WEST SUSSEX COUNTY COUNCIL CONSULTATION

TO:	Arun District Council FAO:Mr A Wood
FROM:	WSCC - Highways Authority
DATE:	7 June 2021
LOCATION:	25 River Road Littlehampton BN17 5BZ
SUBJECT:	LU/151/21/PL Demolition of existing car garage and the erection of 2 no. two-storey residential buildings comprising 5 no. flats with associated works. This site affects the character & appearance of the Littlehampton River Road Conservation Area & is in CIL Zone 4 (Zero Rated) as flats.
DATE OF SITE VISIT:	n/a
RECOMMENDATION:	More information
S106 CONTRIBUTION TOTAL:	n/a

drawing Proposed Site Plan

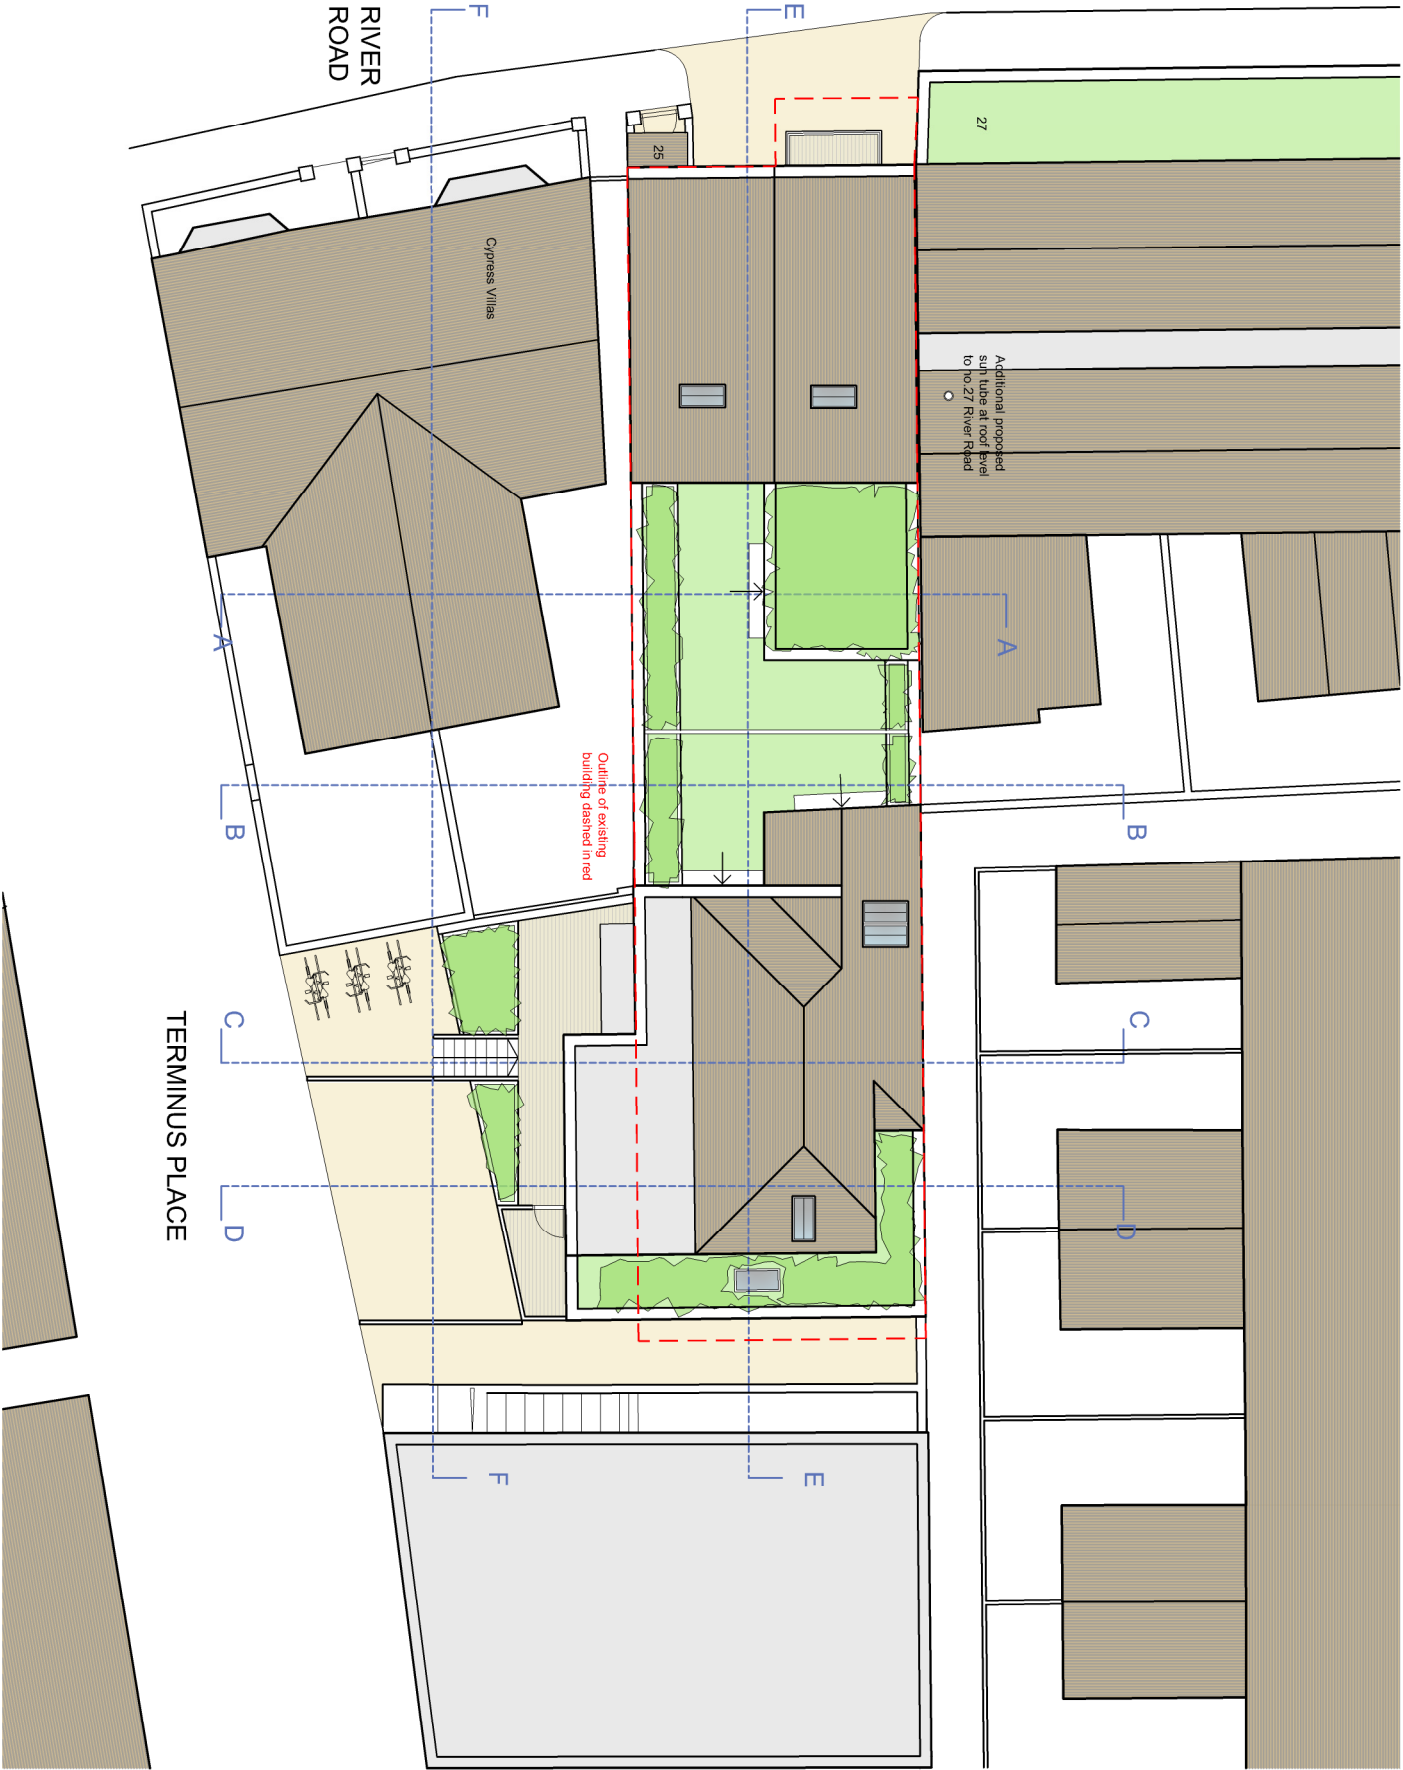
The application from states that 4 parking spaces will be provided for this development, however these have not been demonstrated. Presumably parking will be accommodated within the existing parking area off Terminus Place. The applicant is requested to demonstrate a parking layout plan. A parking bay should meet the minimum requirements of 2.4 x 4.8m as outlined in Manual for Streets (MfS) guidance.

Each parking bay should have 6m manoeuvring space. If 6m cannot be achieved because of the opposing parking bays, the applicant should widen the parking bays accordingly to allow space for manoeuvring. Swept path tracking will be required to demonstrate that the proposed parking spaces are accessible.
